**Date:** 03/27/2024

**Re:** **Head Height Clearance Issue**  
Location: Lot 17 McKay Place (58 Hawksmoore Ln. Lillington, NC)  
JDS Project No.: RDU2403231  
Date of Inspection: 03/27/2024

2nd Floor Plan 'A'  
 SCALE: 1/4"=1'-0" AT 22'X34' LAYOUT 1/8"=1'-0" AT 11'X11' LAYOUT

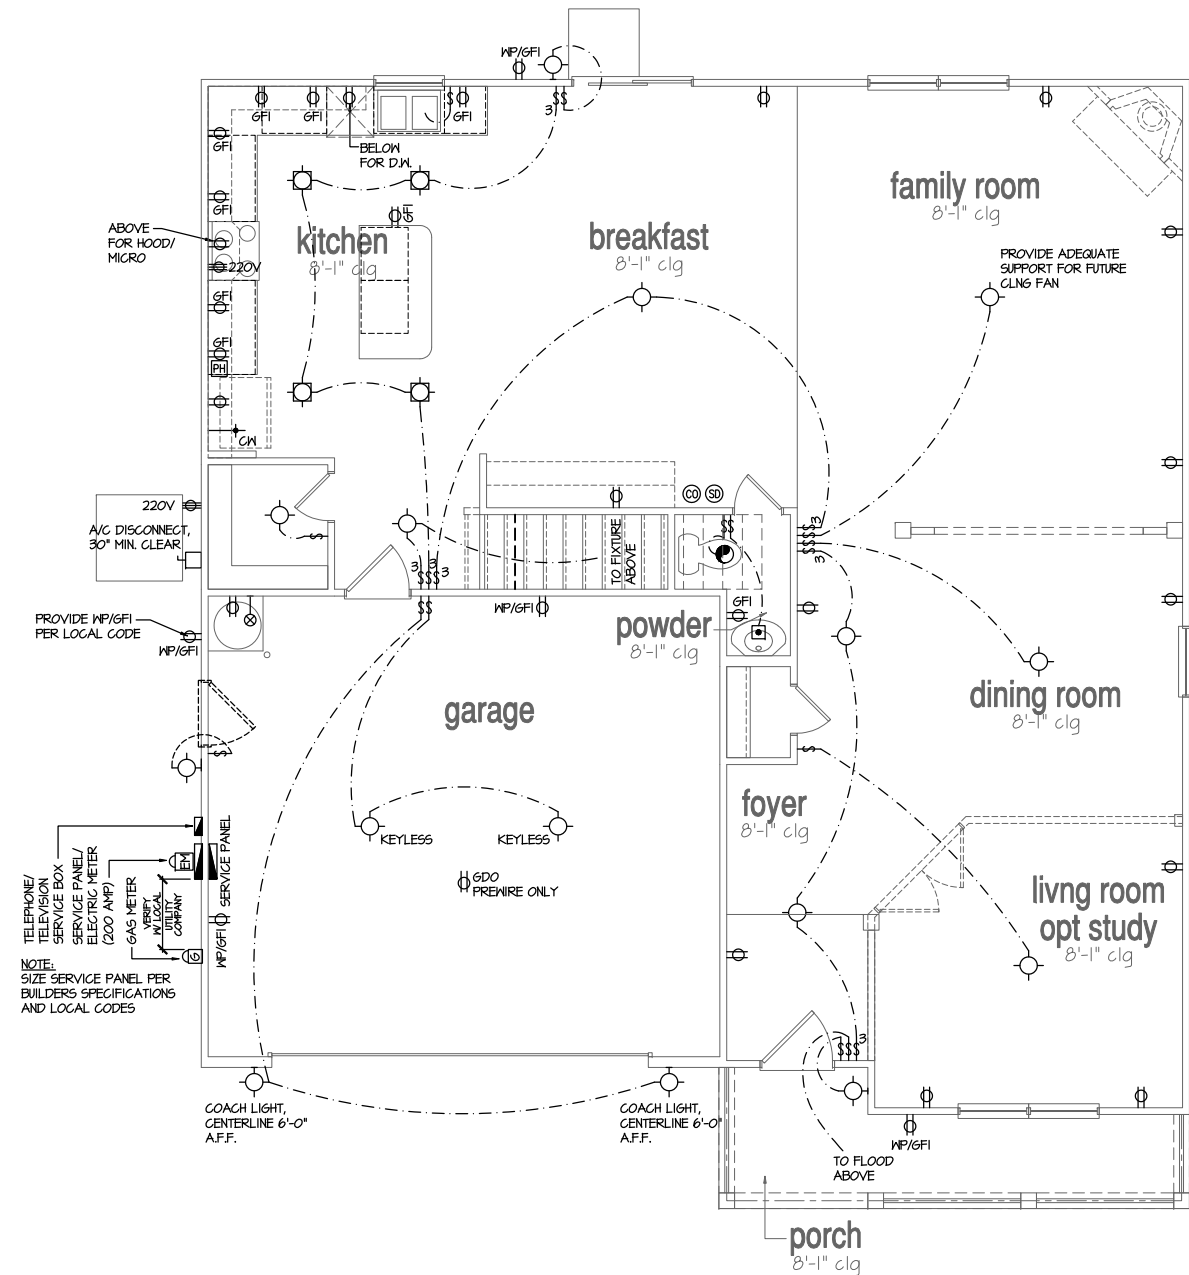
The client requested specifications to solve an issue on site where the clearance between an I-joint and the stairs leaves only 75" rather than the required 80". It was observed on site that the I-joint in question is a 14" deep BCI 4500 spanning 4' across the stairs. The I-joints are spaced 19.2" o.c. and directly above this I-joint is a non load-bearing wall.

- 1) Remove drywall as necessary and temporarily support the framing.
- 2) Remove the interfering I-joint and replace with a 2x6 beam of equal length. Install the 2x beam flush to the underside of the floor/wall above by installing vertical 2x blocking cut to the required size in the pockets at each bearing end. Secure the blocking and beam to the surrounding framing with 10d nails.
- 3) To transfer full bearing from the wall above, install an additional 4' long 2x4 to the 2x6 flush along the underside of the flooring, attached with (2) rows of 10d nails.
- 4) Install additional nailing boards as necessary to form new slope for ceiling between 2x6 beam and 14" I-joint.
